Date	Project Name & #	Action Request	Action Taken
3/16/05	Westland North TRF Proj 1004005	Sketch Plan	Comments (NW Mesa Escarp. Plan View Boundaries)

DEVELOPMENT REVIEW BOARD--SPEED MEMO

DRB CASE NO/PROJECT NO: 1004005

Re: Request Sketch Plat Review for Westland North Property (AKA Grassland Subdivision)

SKETCH PLAT
GRASSLANDS SUBDIVISION
 WITHIN THE
 TOWN OF ATRISCO GRANT
 PROJECTED SECTIONS 17 AND 20
 TOWNSHIP 10 NORTH, RANGE 2 EAST, NMPM
 CITY OF ALBUQUERQUE
 BERNALILLO COUNTY, NEW MEXICO
 MARCH, 2005

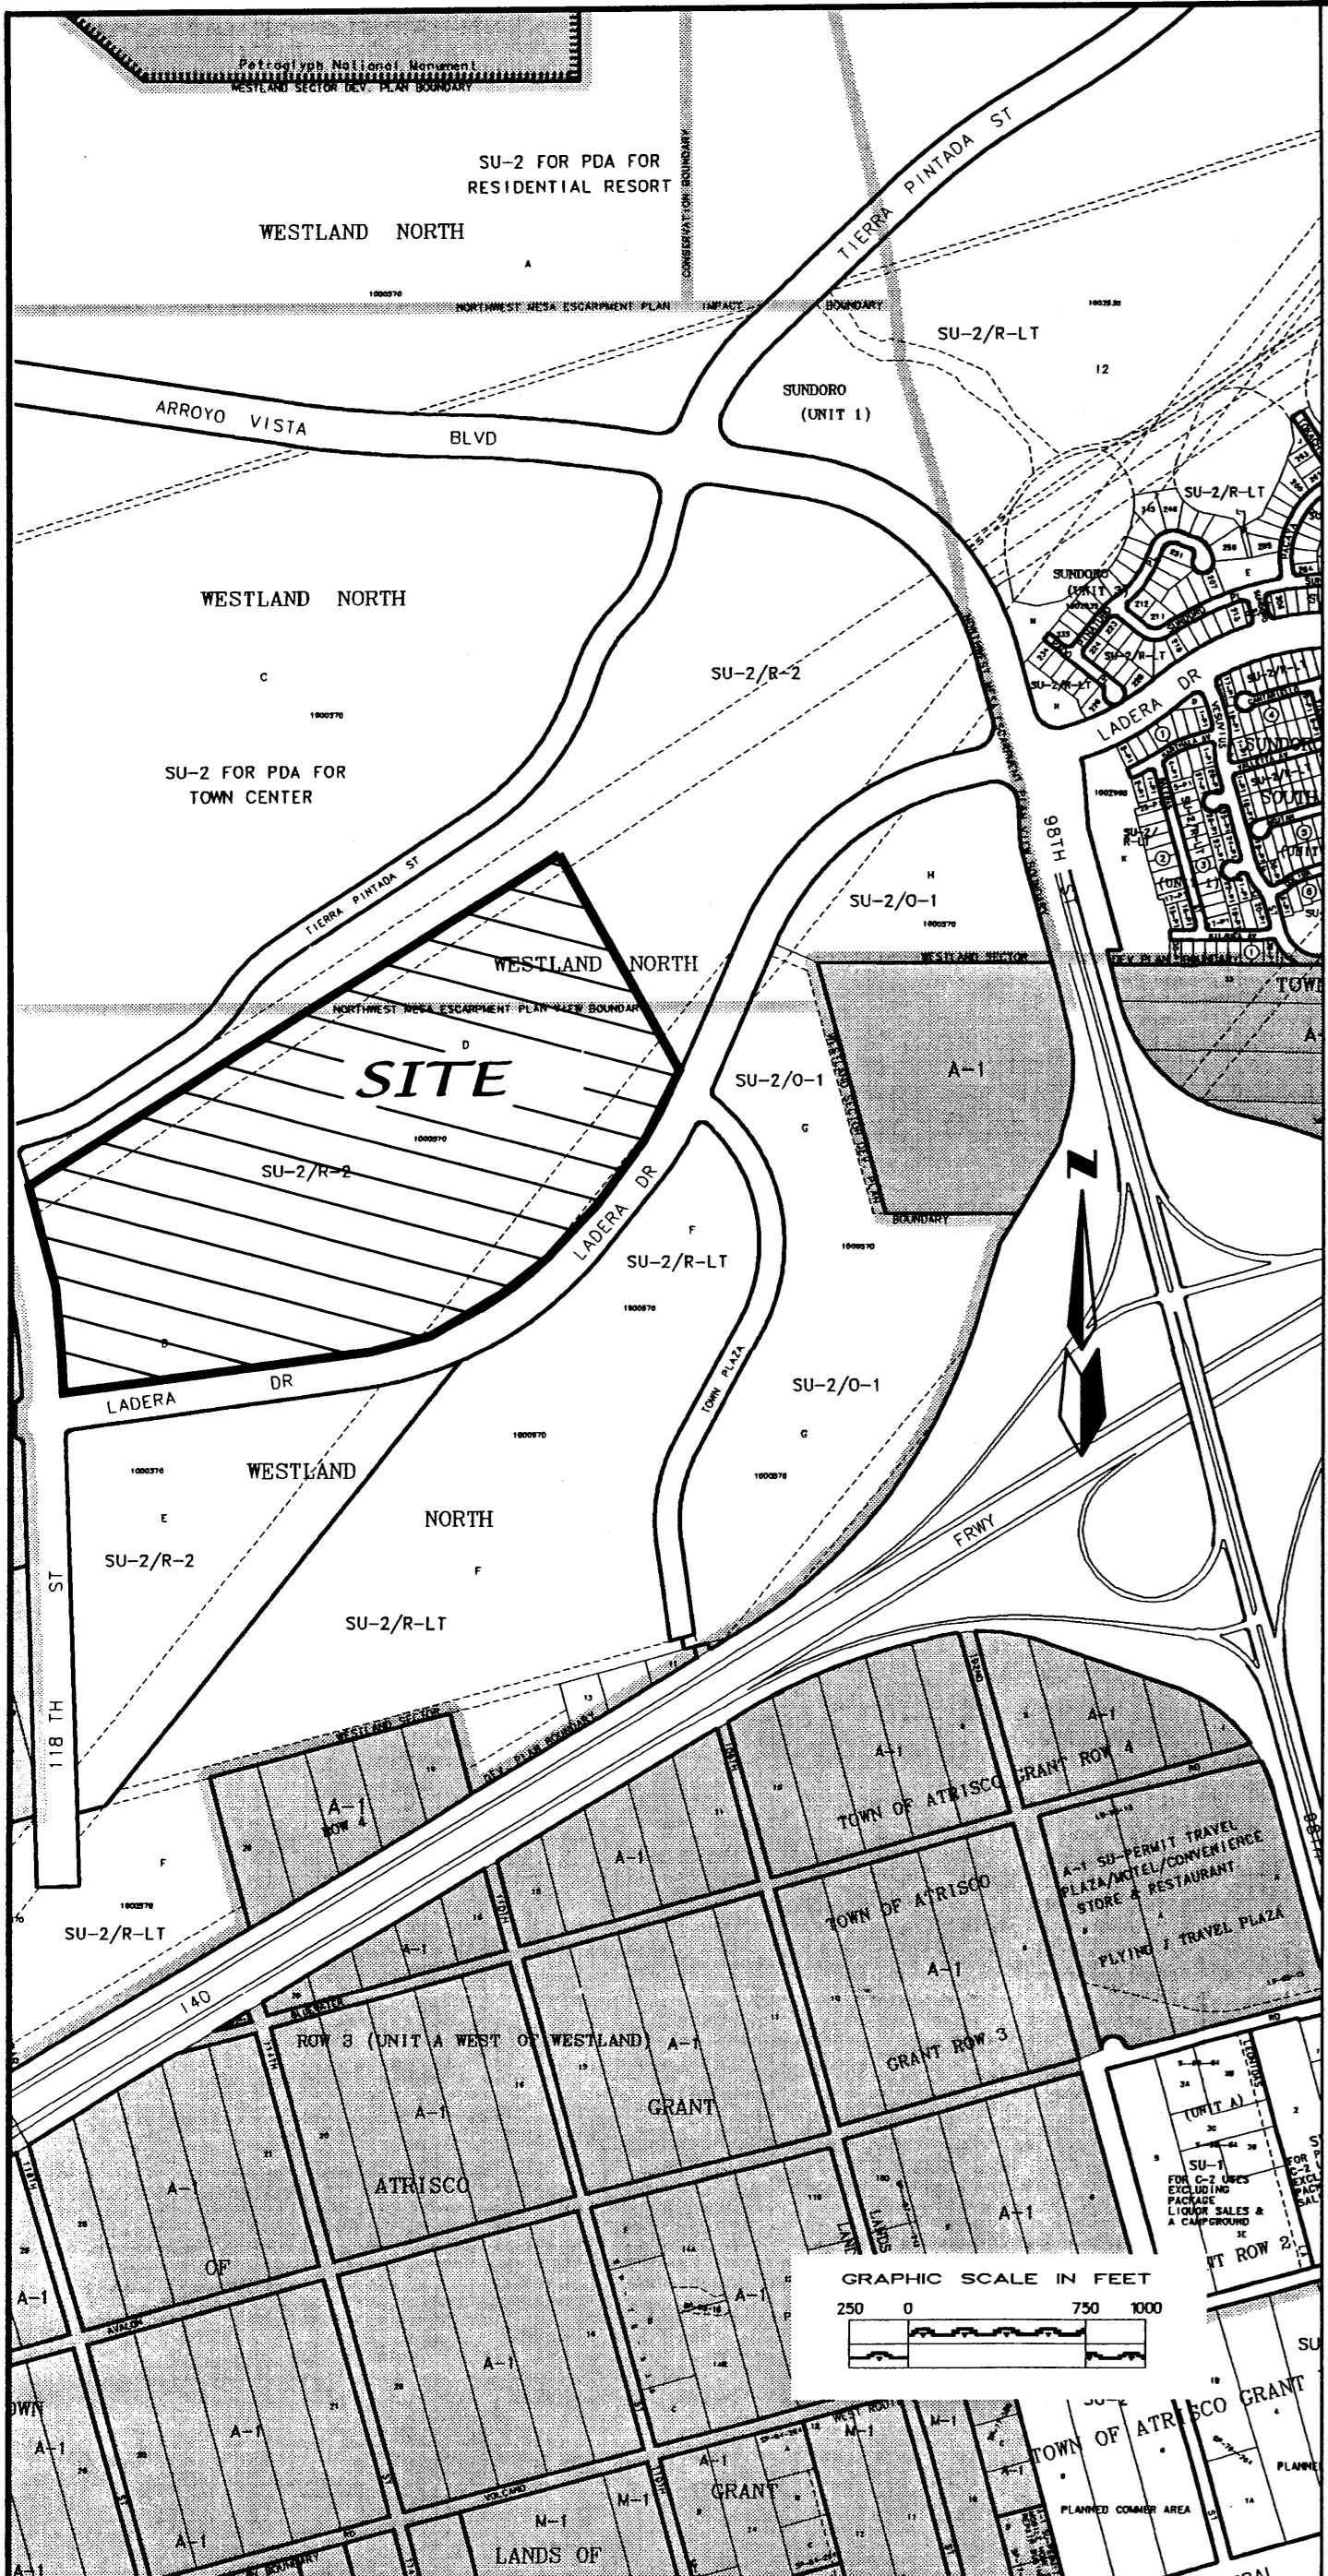
An approved Drainage Management Plan (DMP) for the entire basin is required for preliminary plat approval.
An approved infrastructure list is required for Preliminary Plat approval.
